CITY OF ALBUQUERQUE

Re: Coal Townhomes
714 Coal Ave. SW
6 Requested for Permanent C. O. - Accepted
Engineers Stamp Date 5/27/15 (K13D073)
Certification dated: 5-27-16

From: Elliott, Stanice
Sent: Tuesday, June 07, 2016 12:45 PM
To: 'David Soule'
Cc: Abiel X. Carrillo
Subject: 714 Coal Townhomes

ENGINEER'S SEAL DAVID SOULE NEW MEXICO REGISTERED PROFESSIONAL ENGINEER 14522	LOT 8-A RAYNOLD ADDITION GRADING AND DRAINAGE PLAN <i>Rio Grande Engineering</i> 1606 CENTRAL AVENUE SE SUITE 201 ALBUQUERQUE, NM 87106 (505) 872-0999	DRAWN BY JDG DATE 05-20-2015 SHEET # 1 OF 1 JOB #
---	--	--

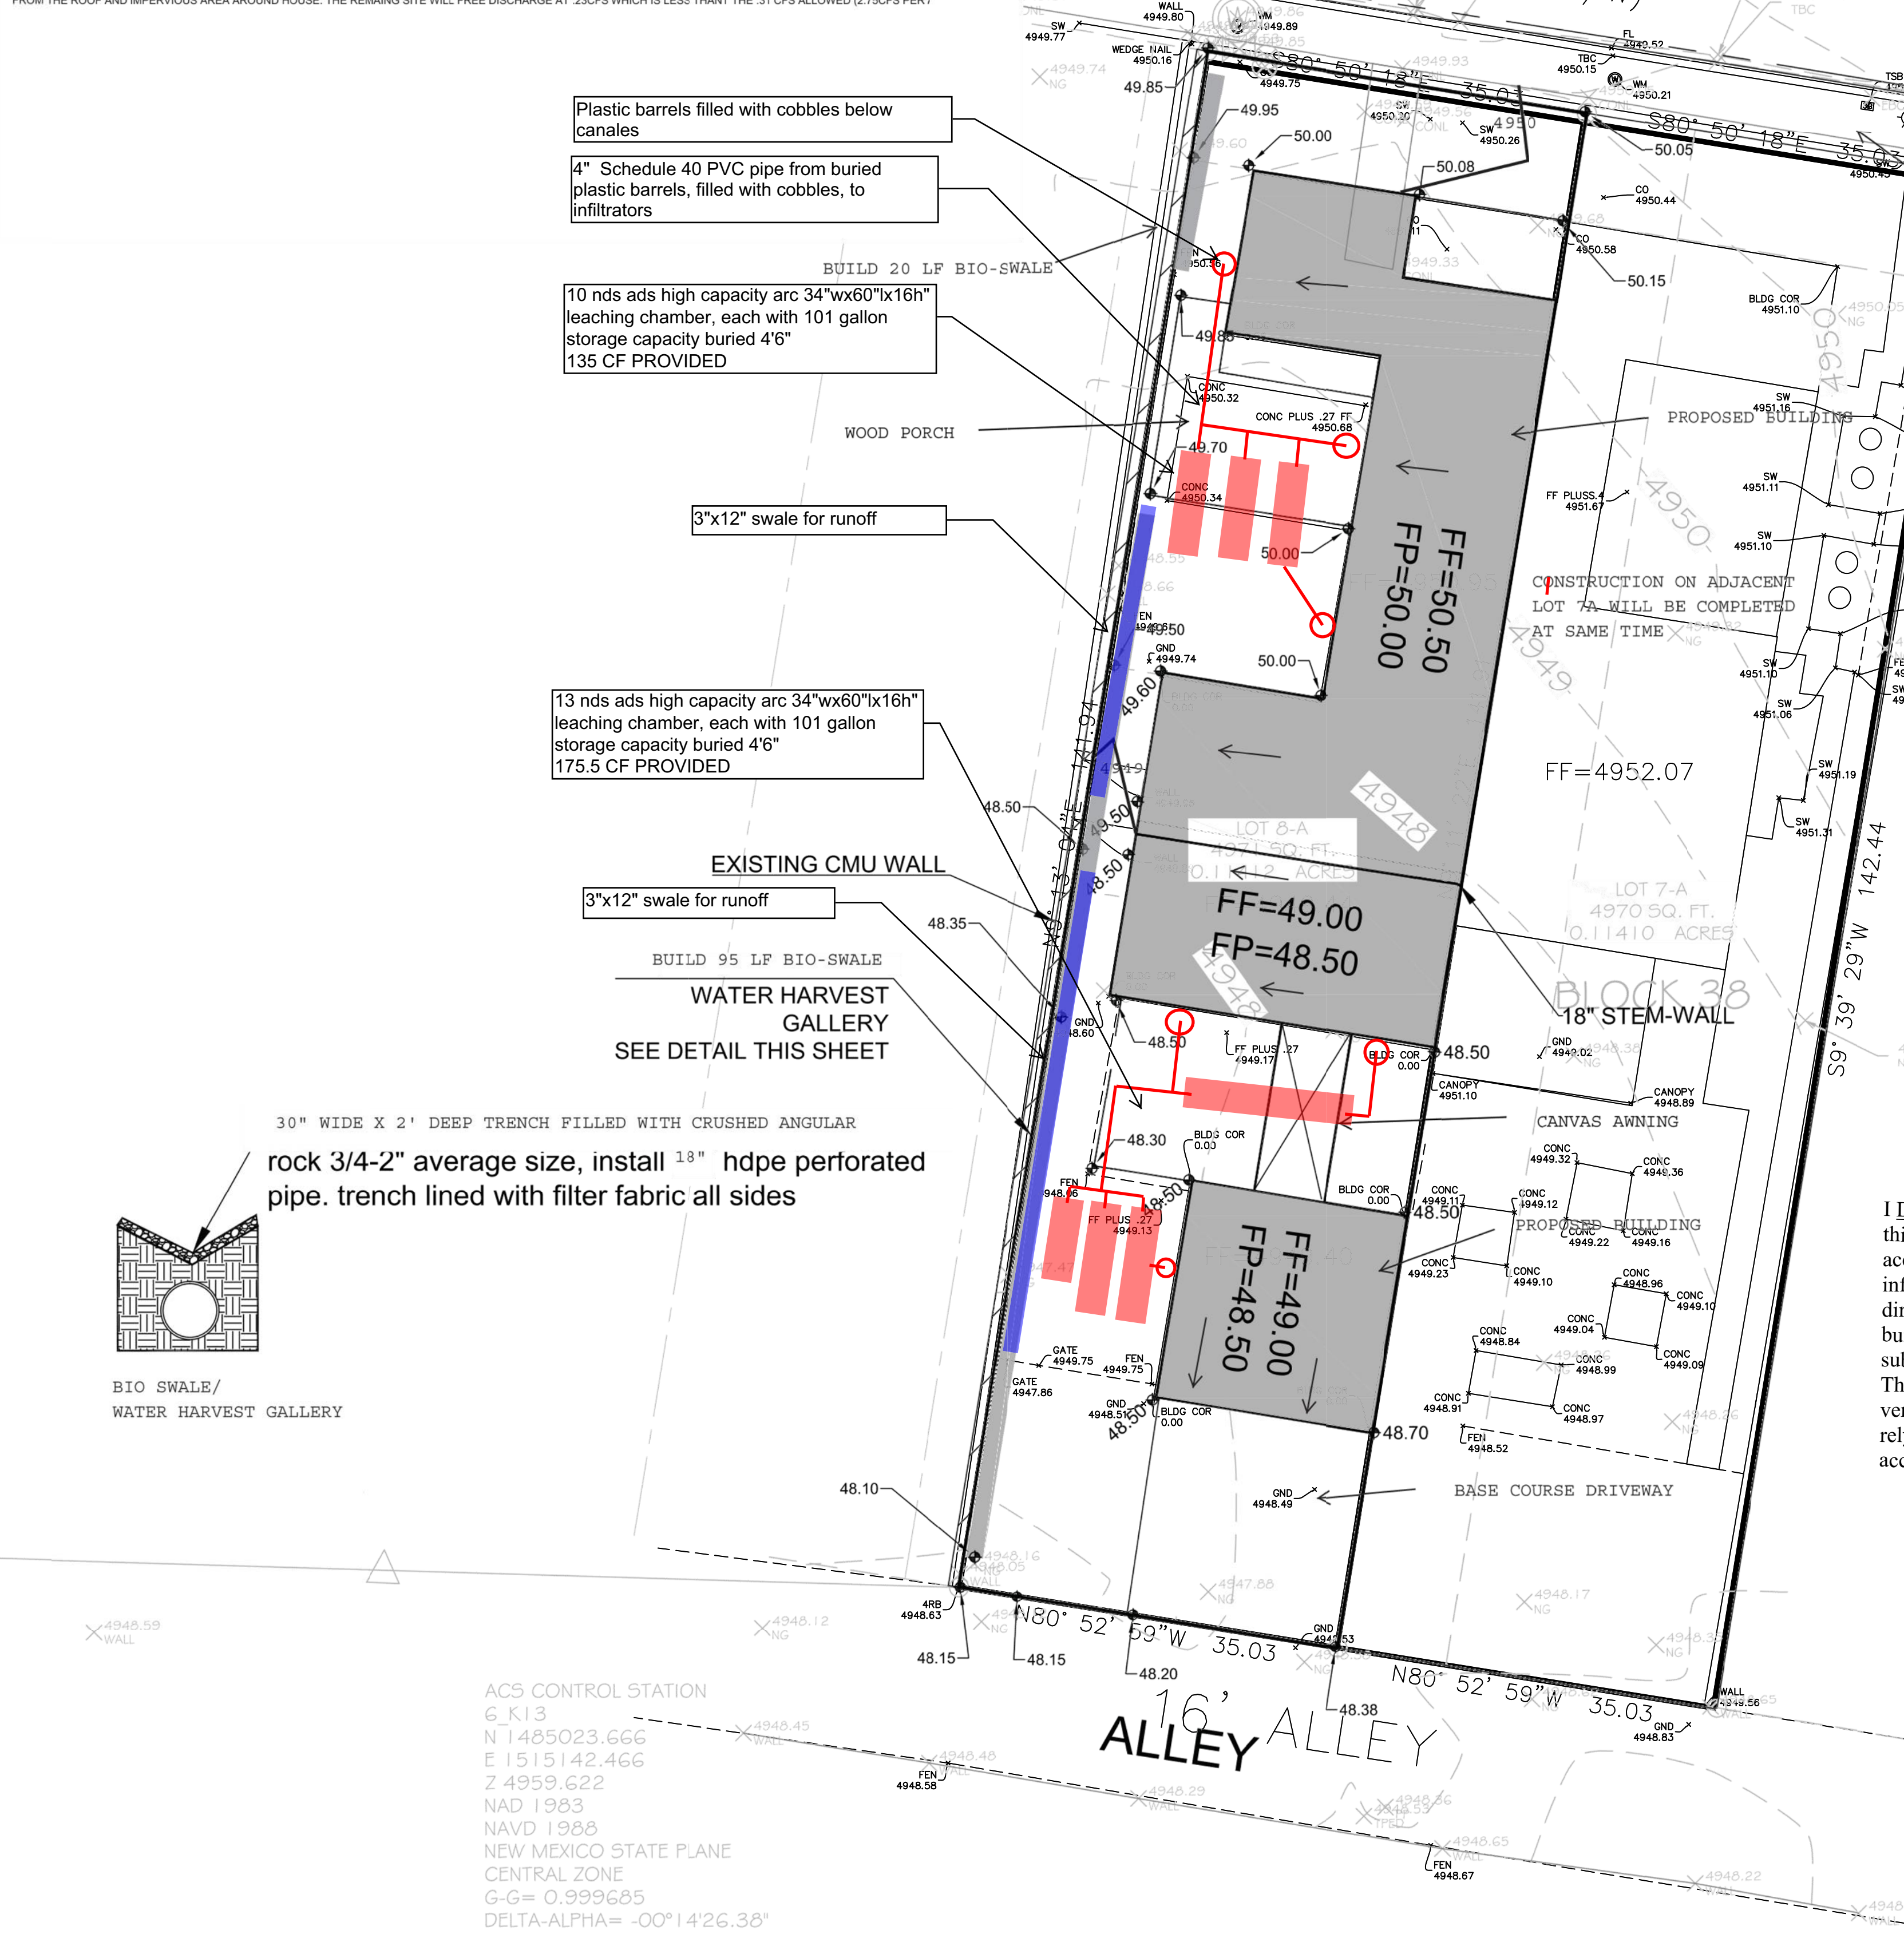
- The swale that runs north to south on the west side is not complete.
